KIRKLEES METROPOLITAN COUNCIL INVESTMENT & REGENERATION SERVICE

DELEGATED DECISION TO DETERMINE PLANNING APPLICATIONS

Reference No:	2026/62/91739/W
Site Address:	23, Rectory Drive, Kirkheaton, Huddersfield, HD5 0JT
Description:	Removal of existing conservatory and erection of single storey side extension including associated works
Recommending Officer:	Ellen Gilbert

DECISION – CONDITIONAL FULL PERMISSION

Proposed Front Elevation -
South

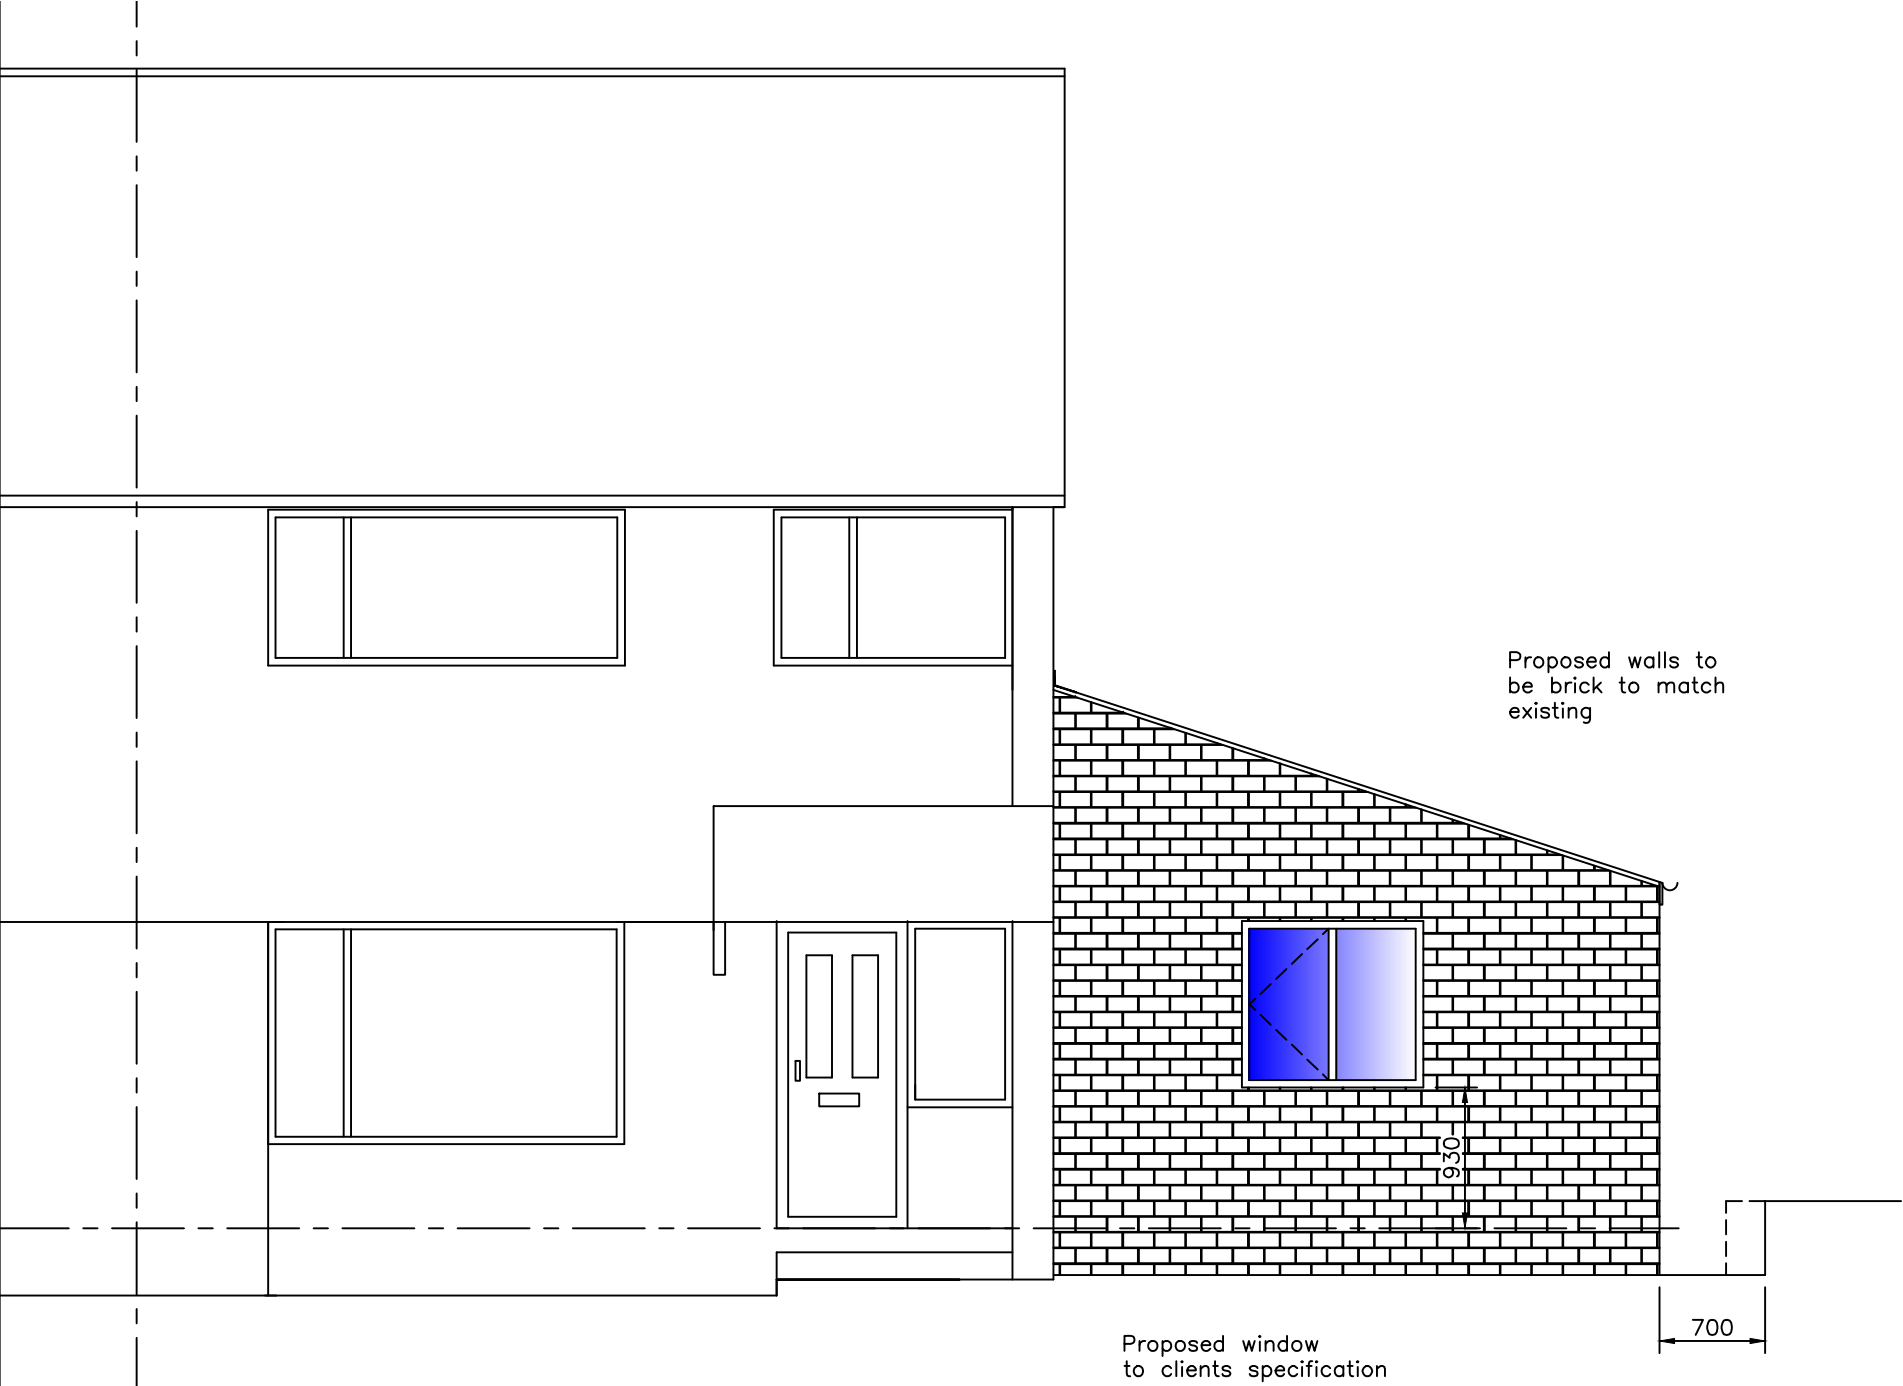
It is noted that the scale on the submitted elevations is stated as 1:50 although there is an annotation stating 1:150. Given the annotated measurement of the floor to cill height scales accurately at 1:50 it is considered to be clear the submitted plans are at scale 1:50.

**Proposed Ground Floor
Plan** 1:50

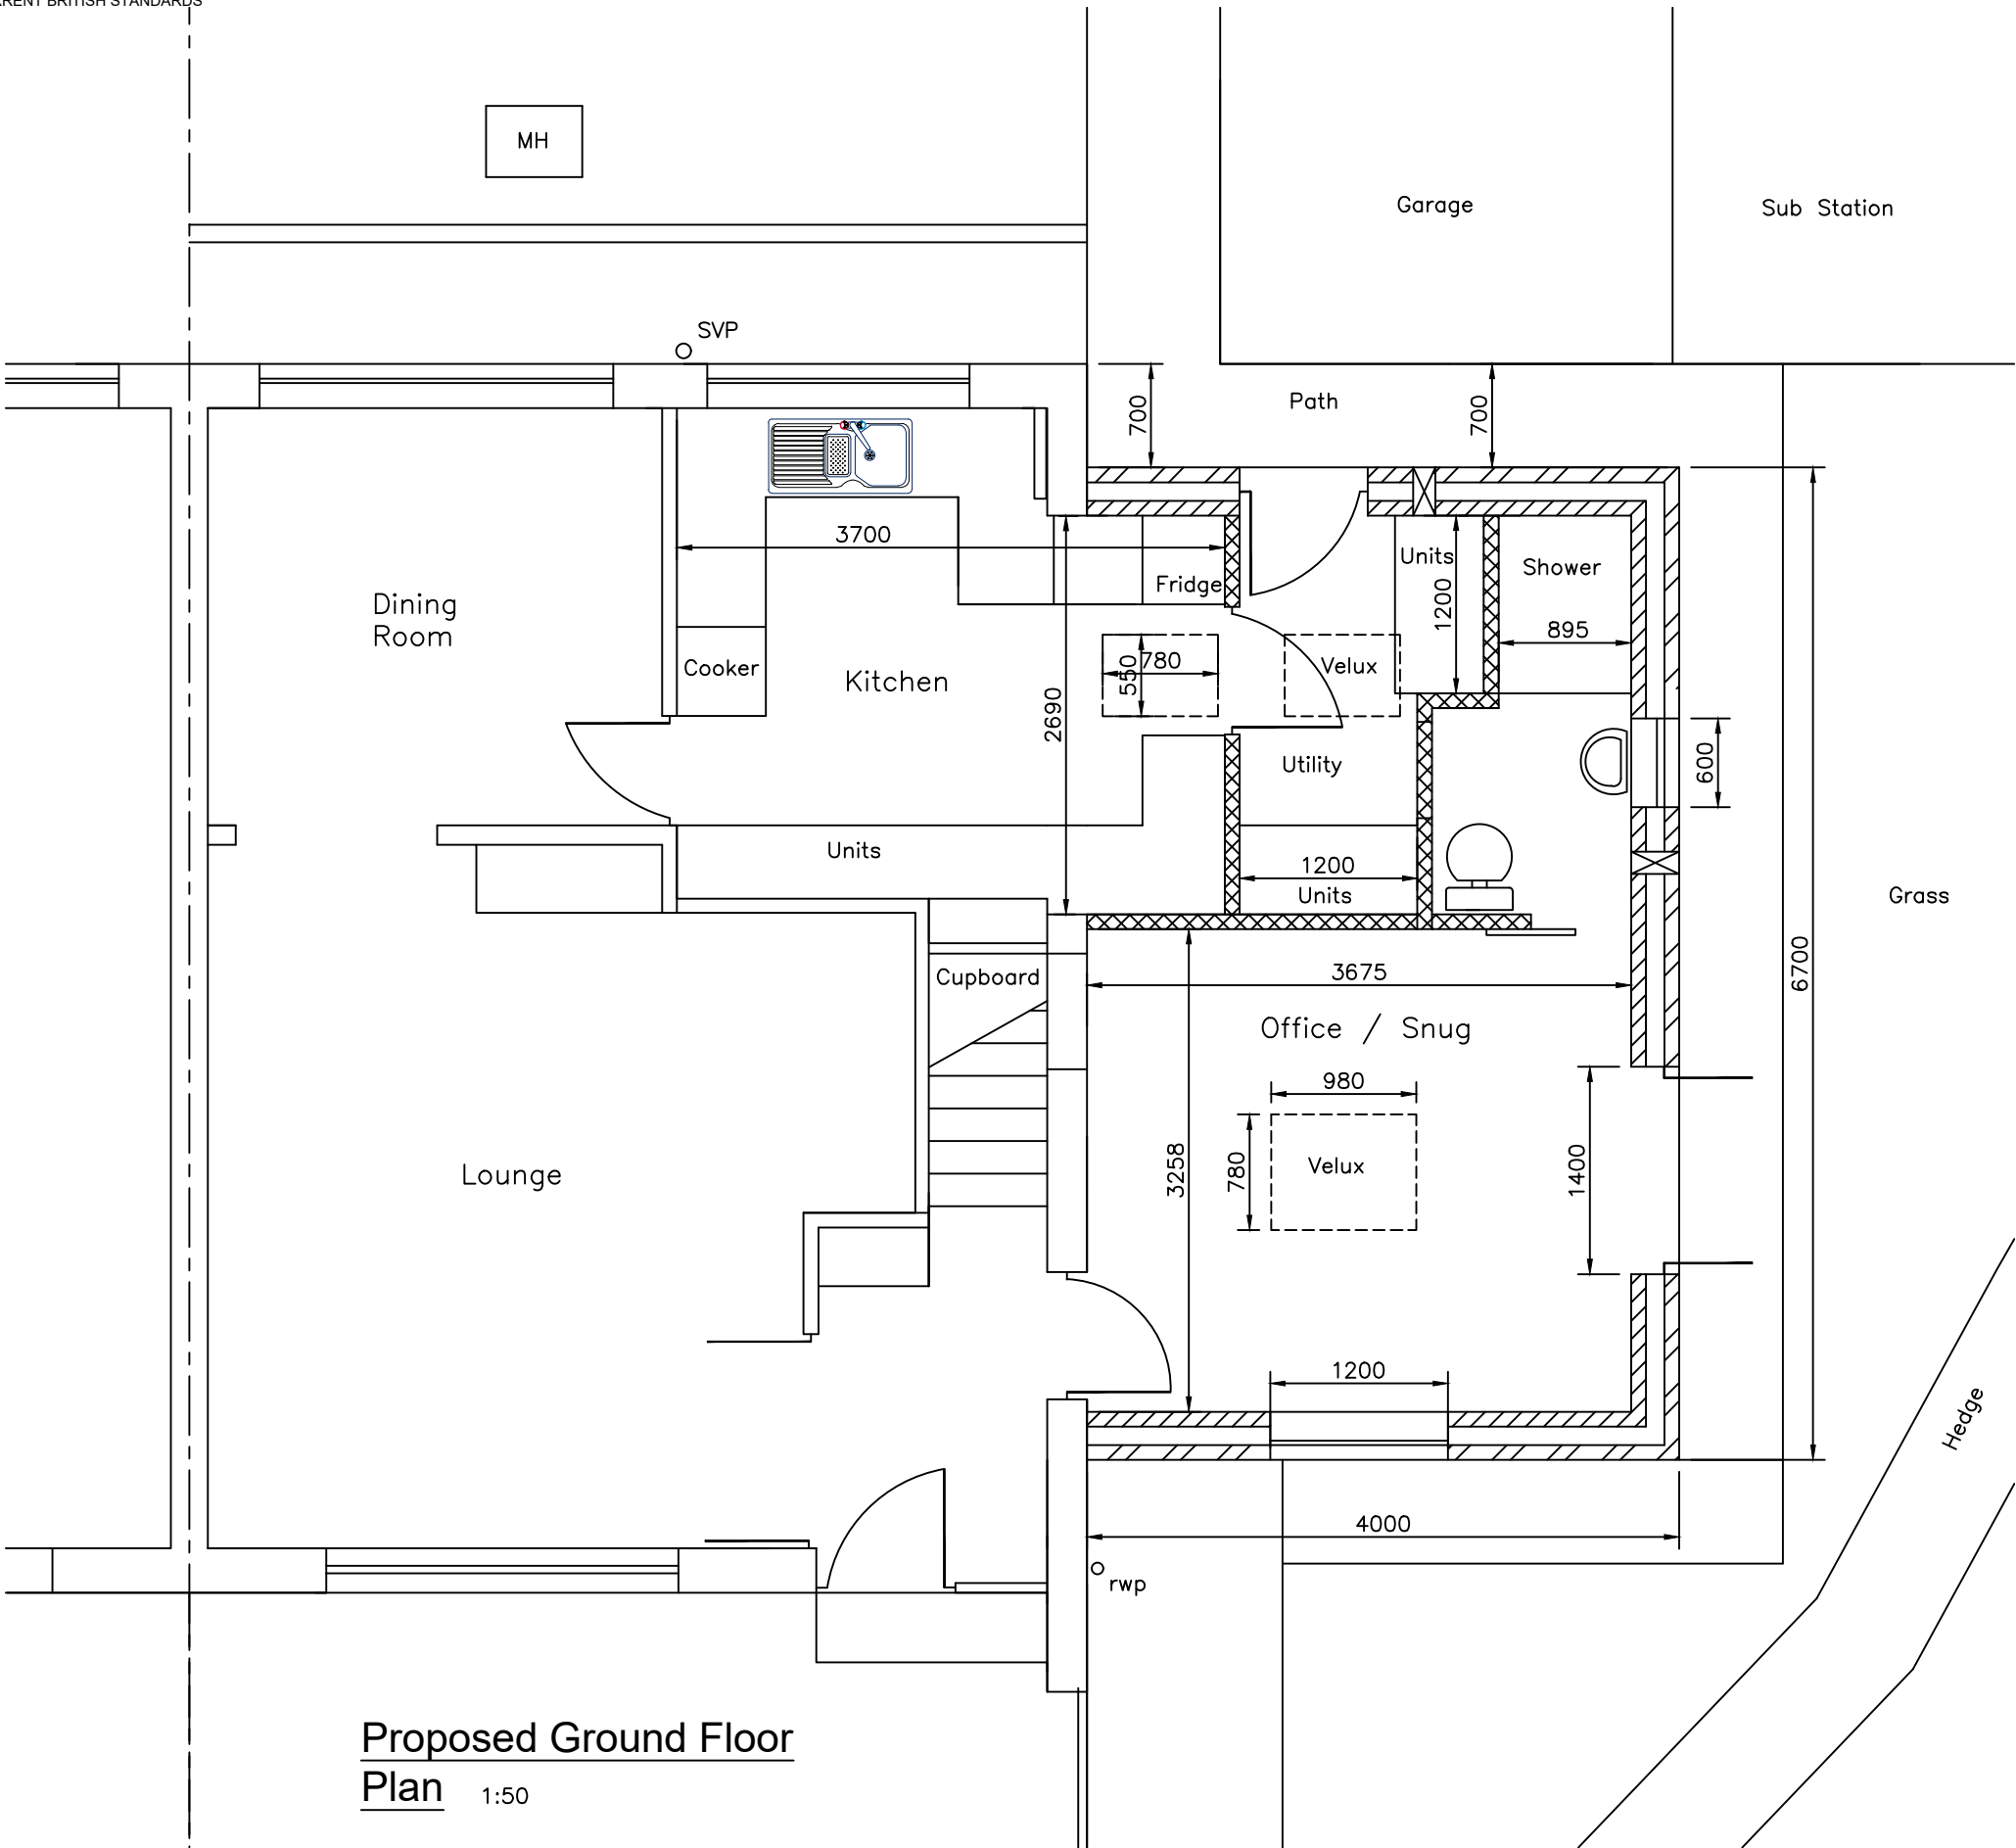
- Proposed Site Plan (ref: 2026/527/07)
- Proposed Ground Floor Plan (ref: 2026/527/05)

These plans were submitted to include the removal of the existing hedges and their replacement with a 1.8m high timber fence.
